Comments for Planning Application 21/02489/FUL

Application Number: 21/02489/FUL

Address: 15 Claremont Terrace York YO31 7EJ

Proposal: Change of use of dwellinghouse (use class C3) to large house in multiple occupation (sui generis) with single storey extension

Proposed ground floor plan (scale 1:100)

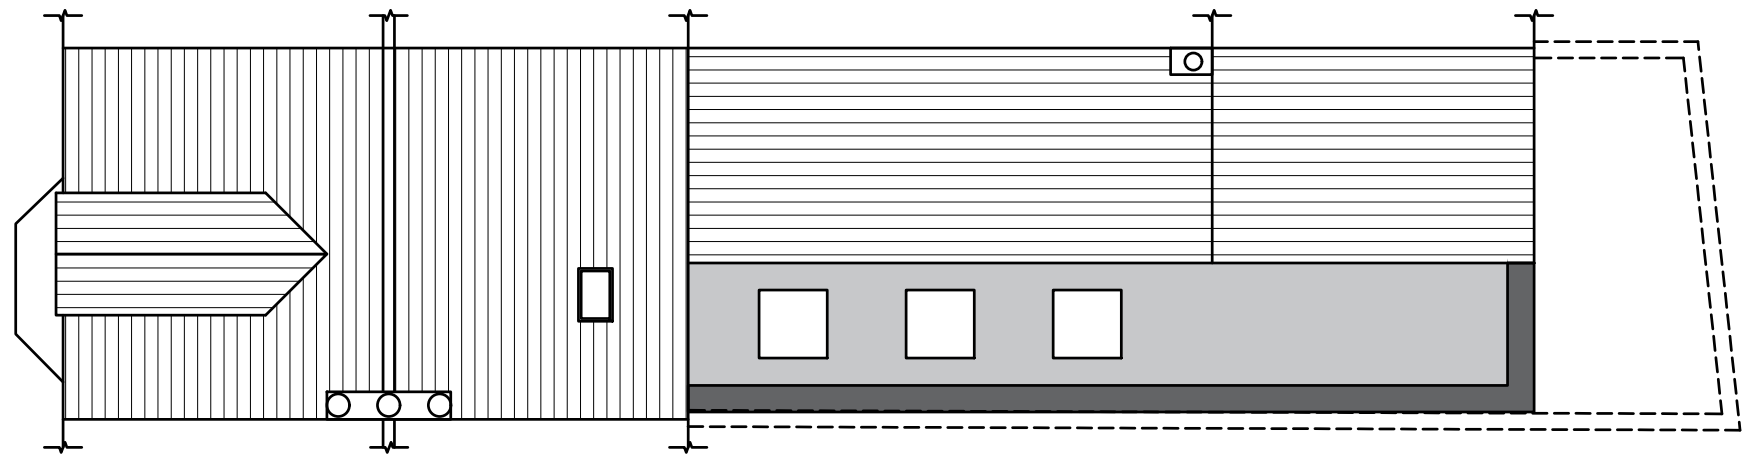
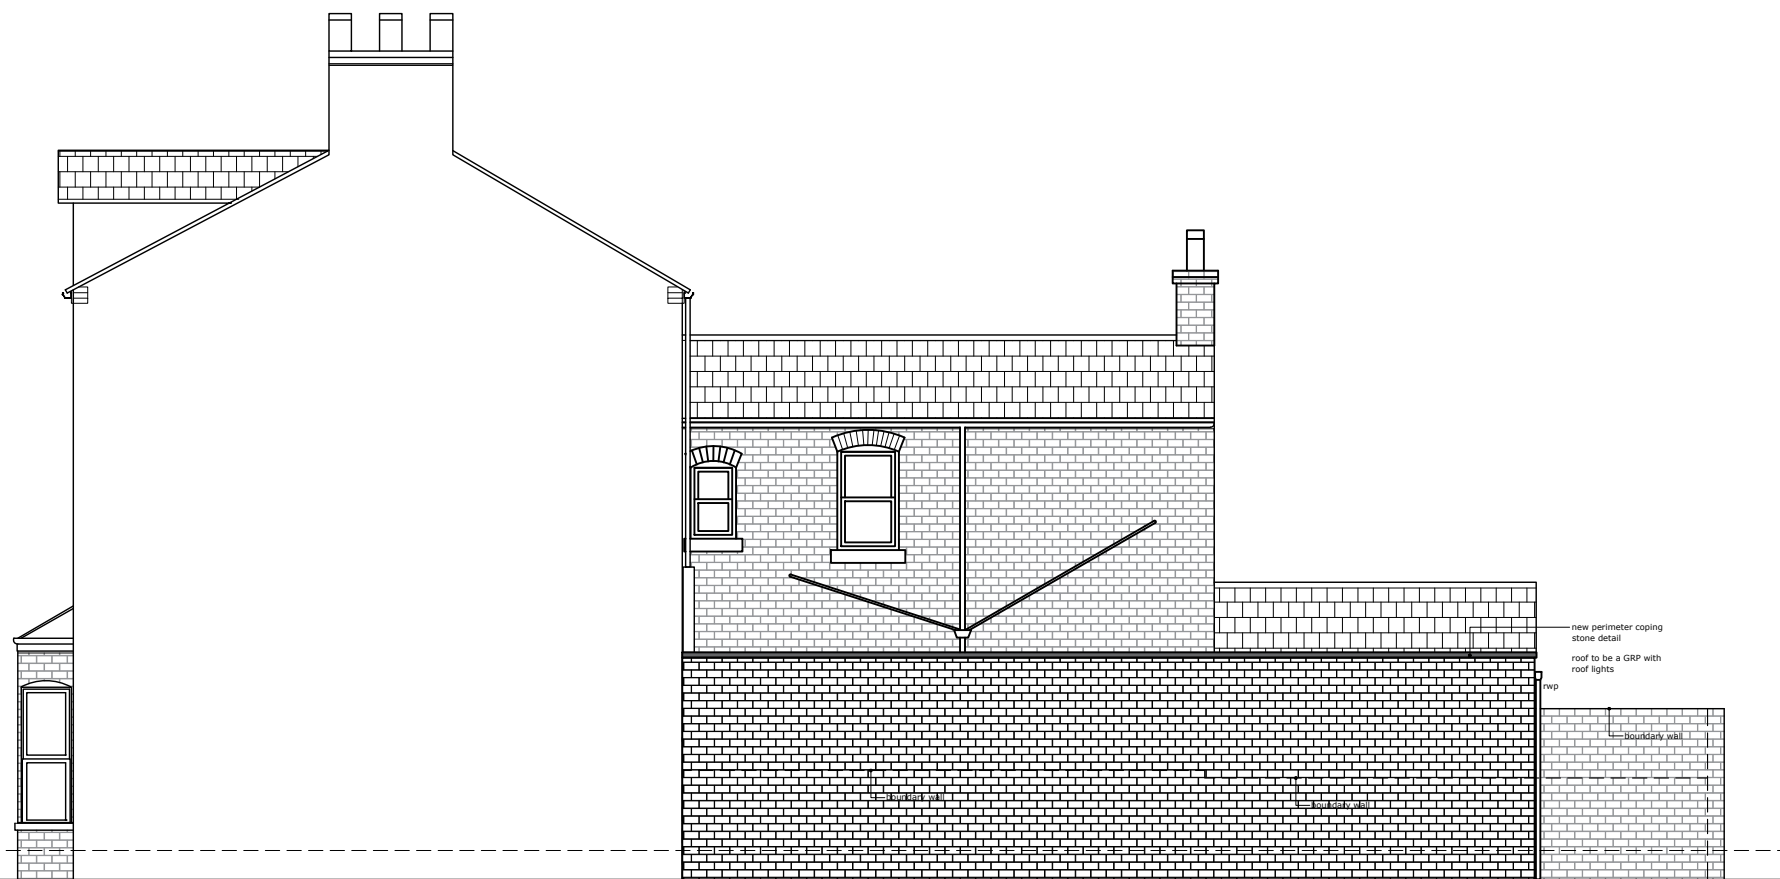
Comment: This is an overdevelopment of the site. Overall provides poor quality accommodation. Limited outside space, no cycle space, no bin storage, cramped communal and shared kitchen space.
